## Appeal Decision

**Appeal Ref: APP/R5510/D/23/3324578**

**78 Roseville Road, Hayes, Hillingdon UB3 4QZ**

- The appeal is made under section 78 of the Town and Country Planning Act 1990 against a refusal to grant planning permission.
- The appeal is made by Mr B Sagoo against the decision of the Council of the London Borough of Hillingdon.
- The application Ref 29767/APP/2023/435, dated 14 February 2023, was refused by notice dated 14 June 2023.
- The development proposed is a first floor rear extension.

PROPOSAL: FIRST FLOOR REAR EXTENSION	DATE: 21.01.2023
SCALE: 1:100	
DRAWING NUMBER: GLA-07L	
DRAWN: J.V	CHECK: R.K
REV:

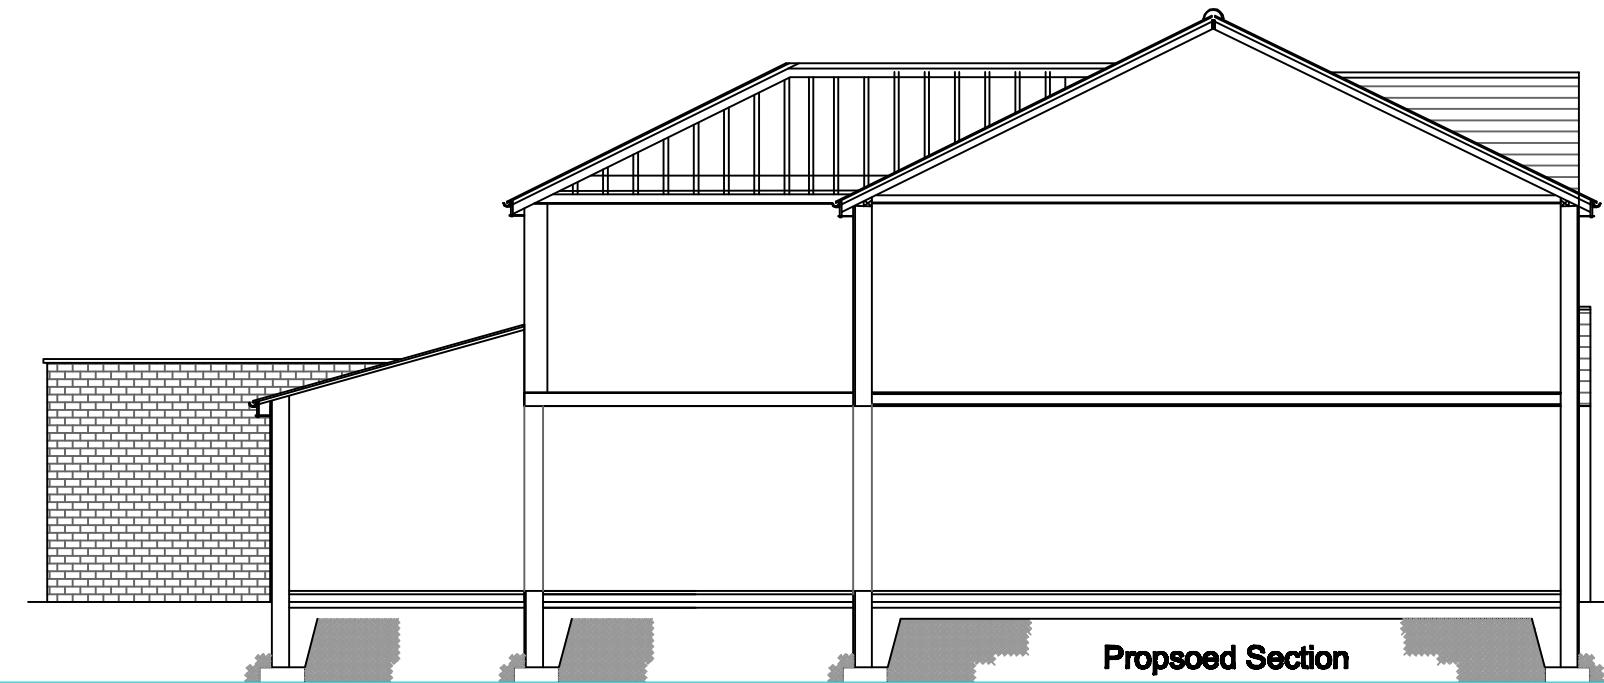
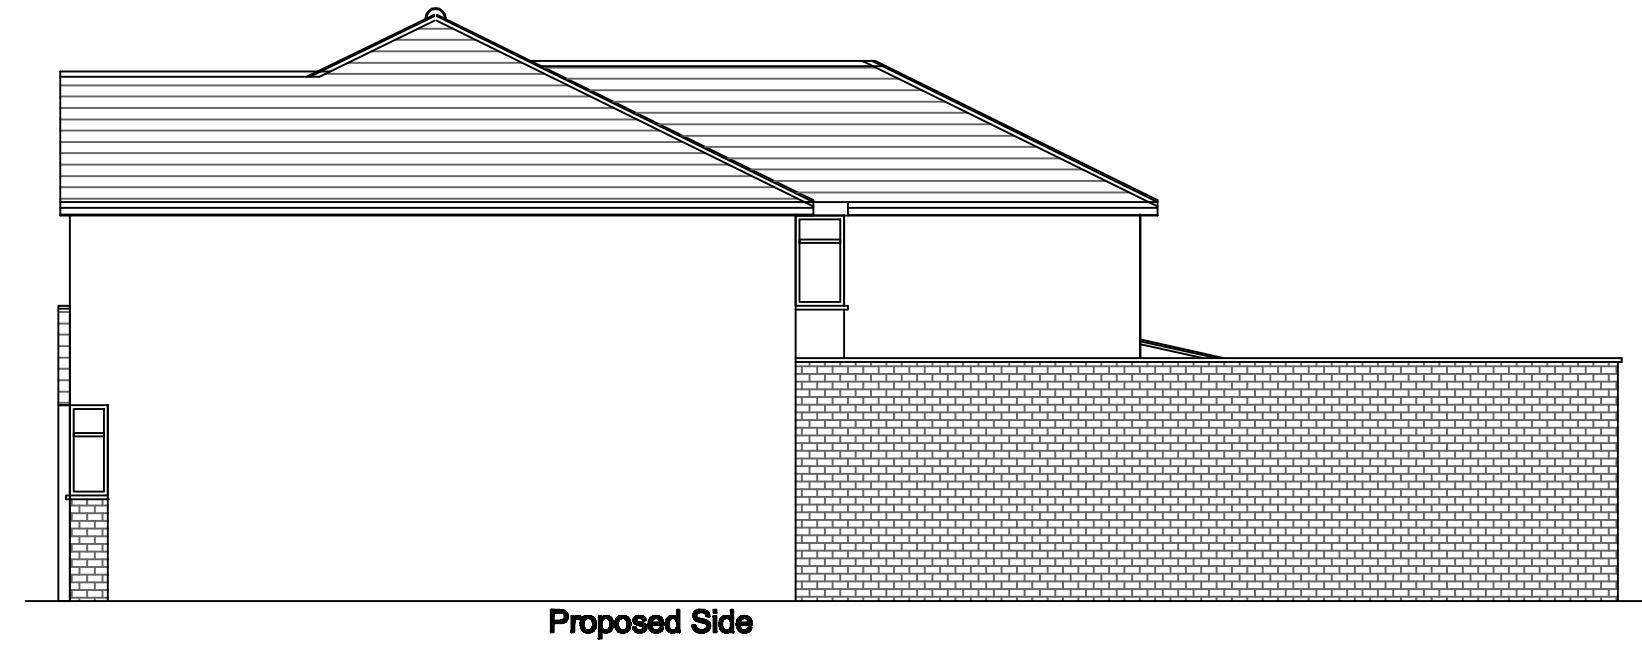
5. The proposed development would be substantial in size, thereby failing to appear as a subservient addition to the host dwelling. Due to the extension's significant width, the design of the hipped roof would create a disparity of angles with the pitch of the main roof. Consequently, the roof form would appear convoluted and fail to reflect the existing architectural detailing of the host dwelling.

6. The proposal would be prominent in views within Hillborne Close. Given its bulk and design, it would be markedly at odds with the less substantial amount of built form in the rear of neighbouring properties, including the first-floor rear extension at 80 Roseville Road (No 80). That extension is not as substantial in size as the proposal and, in addition, it maintains the roof slope of its host dwelling. For these reasons, the proposal would not be justified by the extension at No 80.
